**WELWYN HATFIELD BOROUGH COUNCIL
EXECUTIVE DIRECTOR - PLANNING, PUBLIC PROTECTION AND GOVERNANCE**

DELEGATED APPLICATION

Application No: 6/2019/0866/HOUSE
Location: 6B Hill Rise Cuffley Potters Bar EN6 4EE
Proposal: Retention of detached garage with a reduction in the height of the existing roof
Officer: Mr Tom Gabriel

6/2019/0866/HOUSE

Date:	March 2019	Rev	Details	Date
Scale:	A1@1:500			
Dwg:	33/19			2
Drawn by:	md

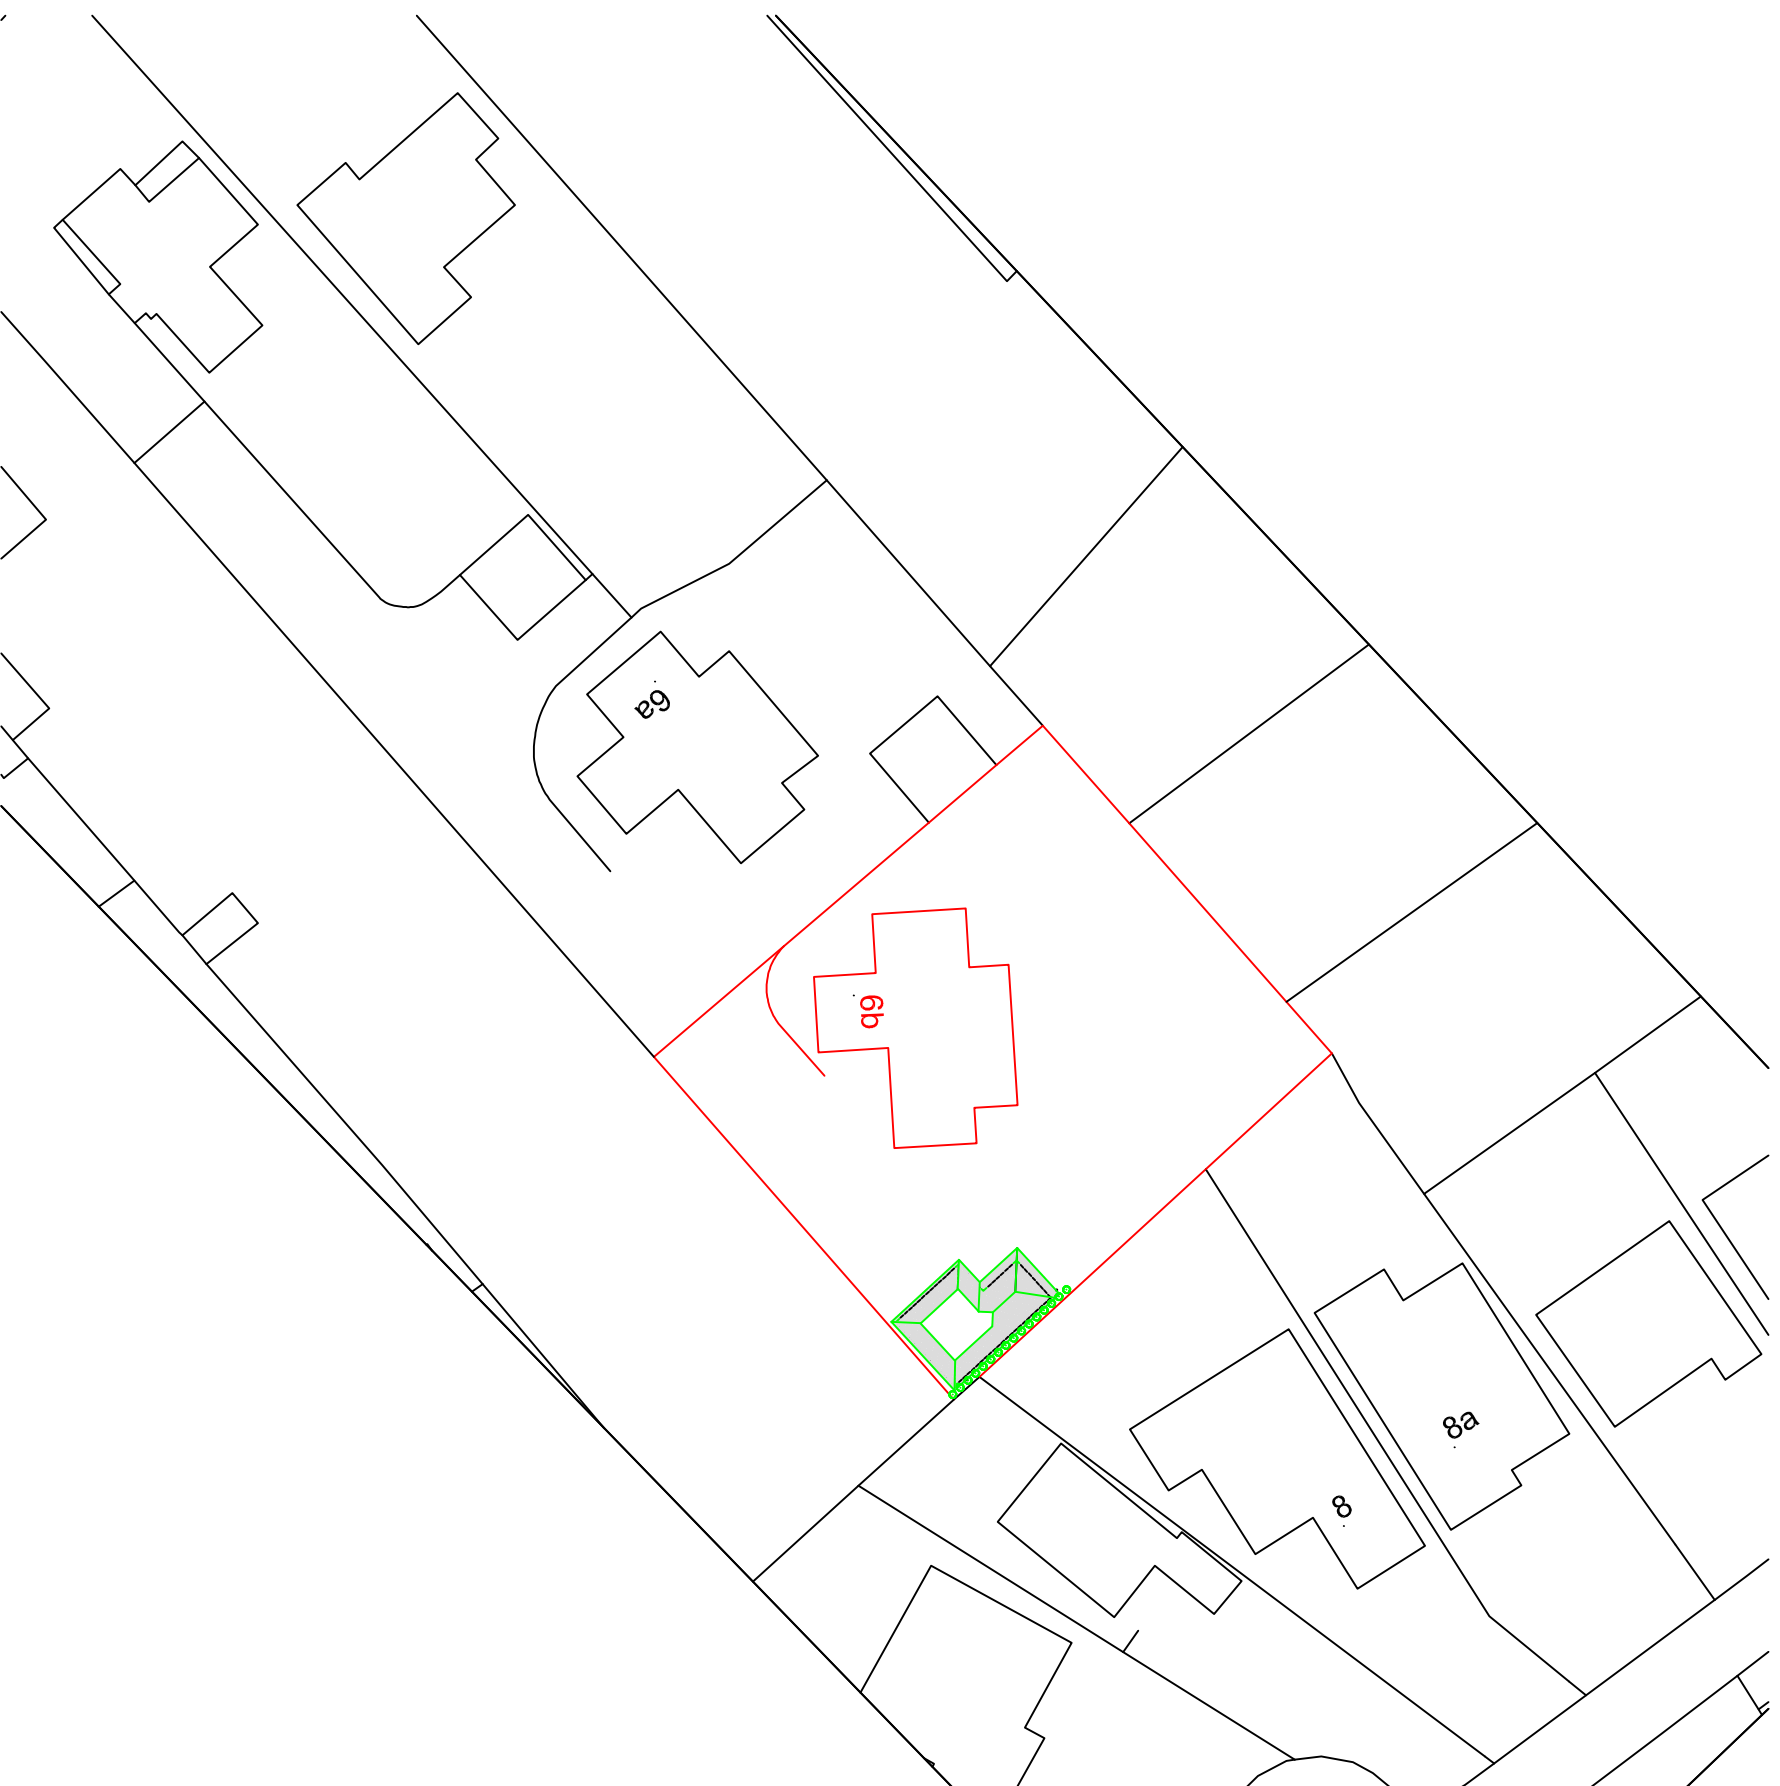
Access, car parking and highway considerations	None.
Landscaping Issues	It is considered necessary to retain the hedge on the rear boundary of the site in order to enhance the visual amenity of the site and the development. This can be secured by condition.
Any other considerations	It is considered necessary to require the amendments to the roof of the garage to be made within three months of the date of this permission, in the interests of the amenities of the occupiers of the neighbouring. This can also be secured by condition.
Conclusion	
A reduction in the height of the garage by 400mm would result in it having an acceptable impact upon the outlook and amenities of the properties to the rear at 7 and 8 Orchard Close. Loss of amenity for the occupiers of these properties would not arise from the garage of the reduced height. The amended garage would relate to the existing dwelling and the site as a whole in a satisfactory manner. The application is therefore recommended for approval.

Dwg: 33/19 3

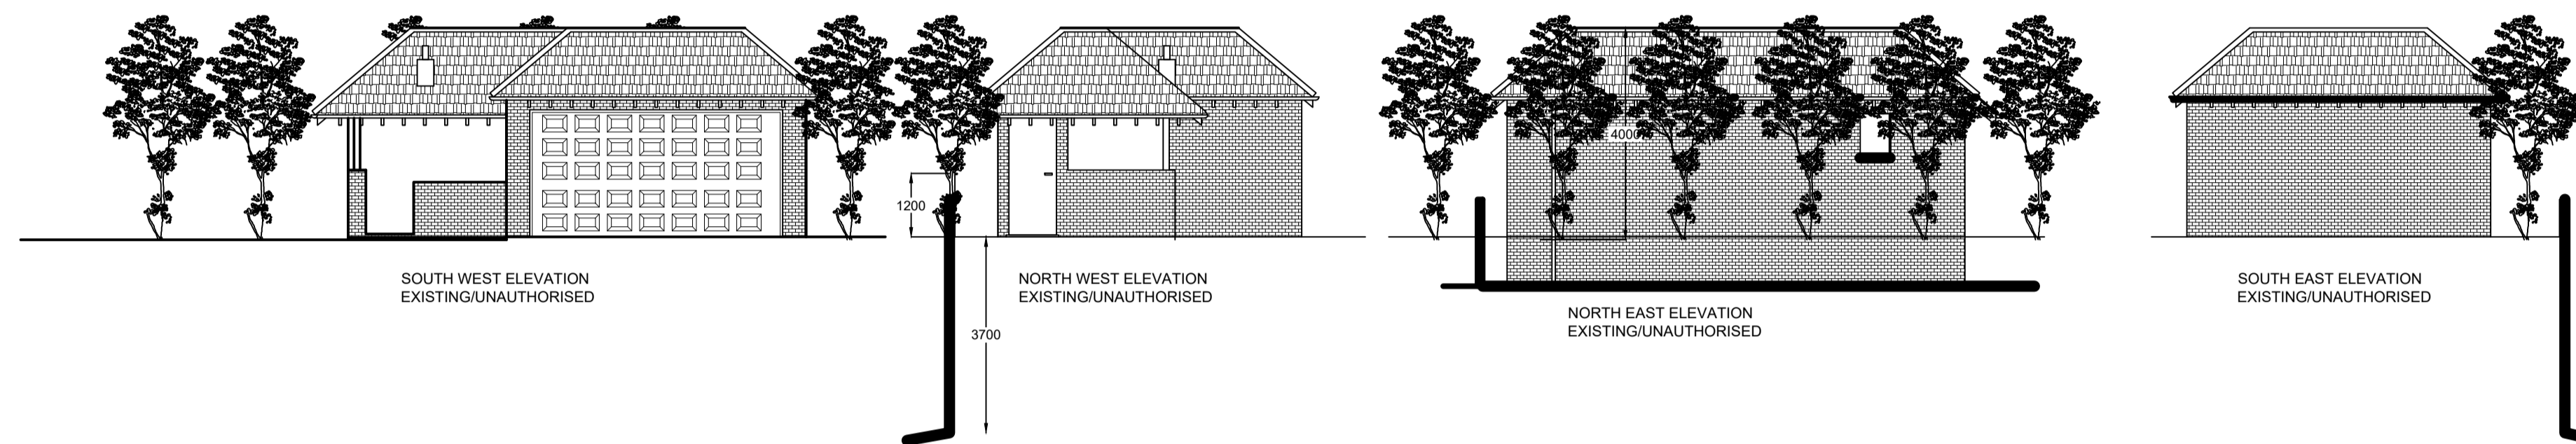
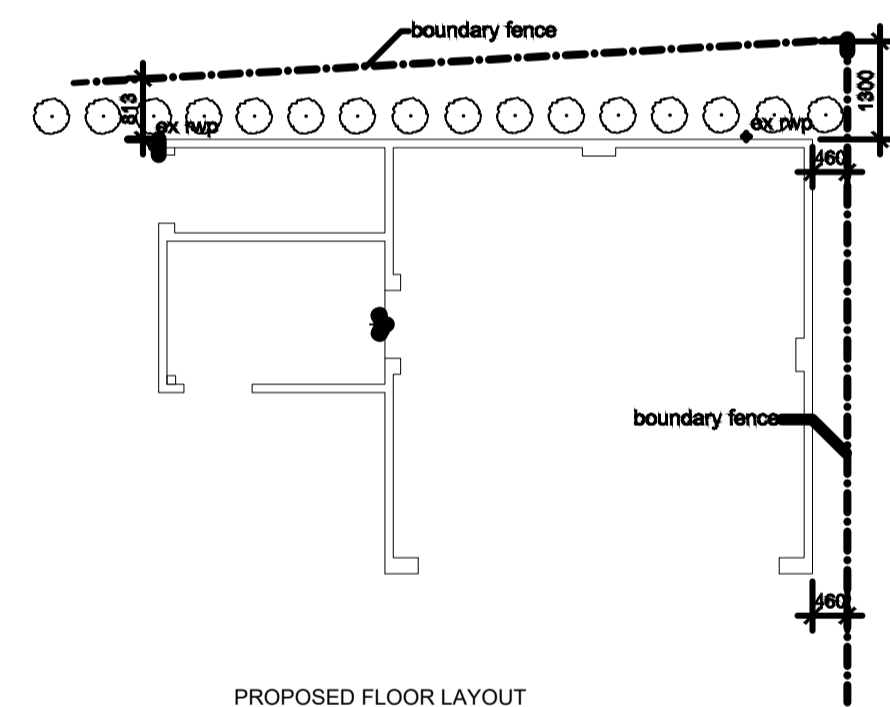
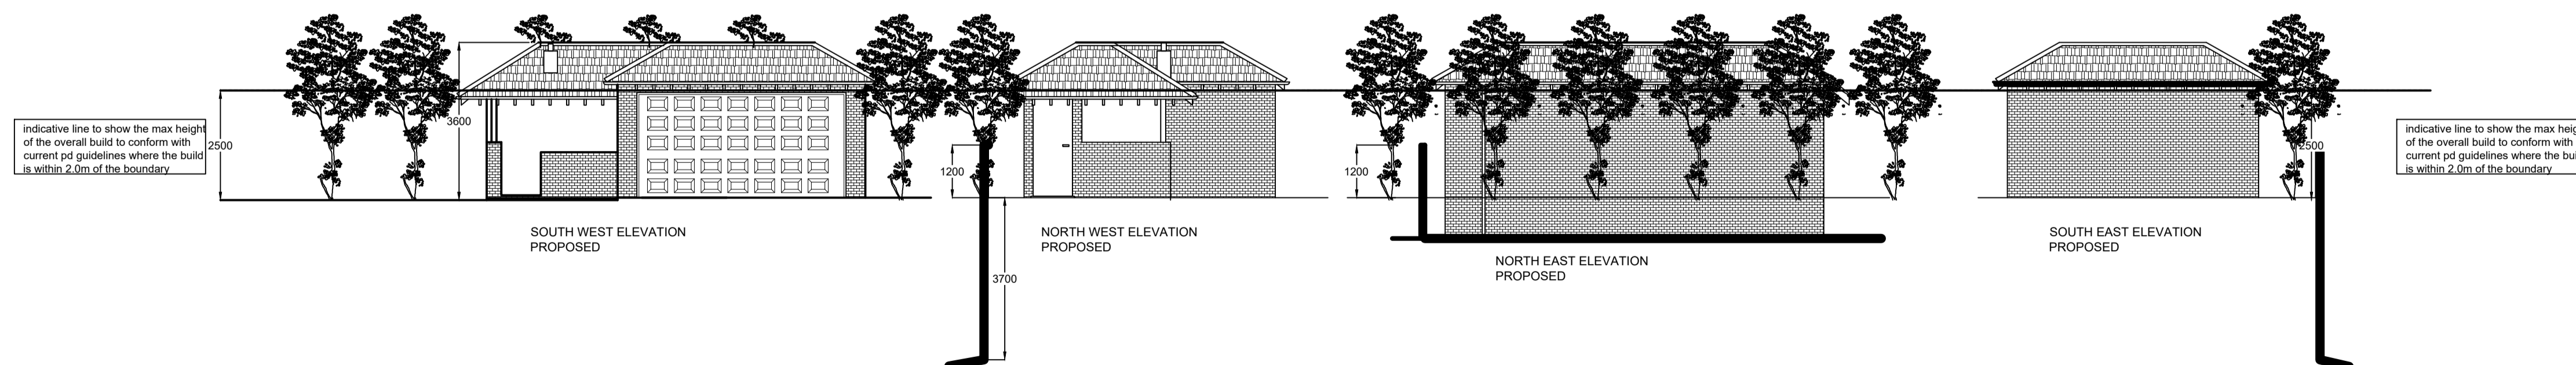
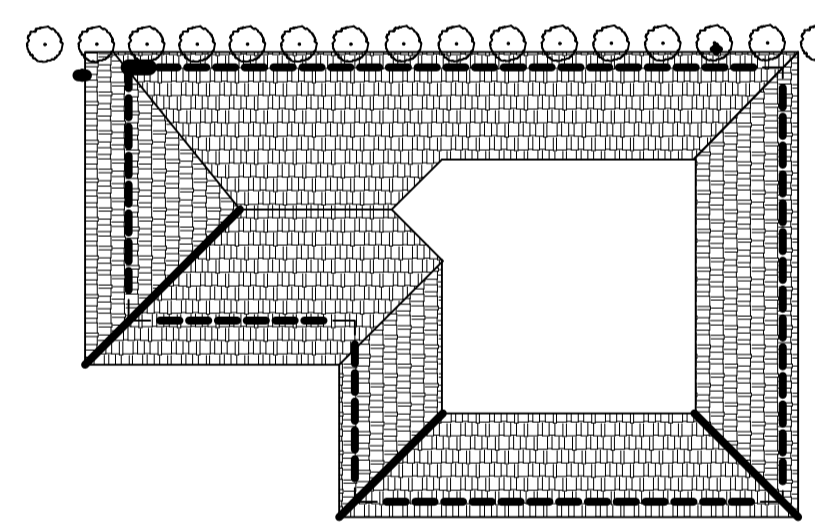
Context	
Site and Application description	<p>The application site is located on the eastern side of Hill Rise, to the rear of No. 6 Hill Rise. The site is accessed via a private road to the side of No. 6. The site comprises a two storey dwelling and detached garage. This detached garage is the subject of this planning application.</p> <p>The surrounding area is residential in character and the site is bounded on all sides by detached and semi-detached residential properties in Hill Rise and Orchard Close.</p> <p>The natural ground level on the site gradually slopes in a downward direction from south-west to north-east. Land levels however drop considerably at the site's north-eastern boundary abutting the rear gardens of a number of dwellings on Orchard Close which are set at a lower level.</p> <p>Planning permission is sought for the retention of the detached garage with a reduction in the height of the existing roof. The height of the roof would be reduced by 400mm to 3.6m, with a crown roof.</p>

Impact on neighbours	<p>The crown roof of the garage would be reduced by 400mm to 3.6m. It would have an eaves height of 2.5m. This is virtually the same height as the garage approved under ref. 6/2016/0038/HOUSE. It is considered that this height is acceptable and that it would not be reasonable to refuse planning permission in this instance when there has not been a material change in the policy framework since planning application 6/2016/0038/HOUSE granted.</p> <p>The resultant garage would not be a dominant or overbearing structure when viewed from Nos. 7 and No. 8 Orchard Close (to the rear of the application site). Neither would the resultant garage result in significant loss of light sufficient to justify refusing planning permission. The impact in terms of neighbour amenity and living conditions is considered to be acceptable.</p> <p>No other neighbours are affected by the detached garage by virtue of its siting in relation to them.</p> <p>Overlooking to the neighbouring properties would not be an issue due to the presence of the property's boundary treatments.</p> <p>The garage incorporates a barbeque area. Its use would likely impact upon the amenities of the neighbouring properties through the smoke that would arise from its use. However, the occupants of the property could have a separate barbeque in their garden without the specific need for permission from the Council. The impact of the barbeque in the garage building is unlikely to be materially greater than a separate barbeque in any part of the site, in terms of neighbour amenity.</p>

1. The roof of the garage shall be reduced in height in accordance with the approved plans within three months of the date of this notice.
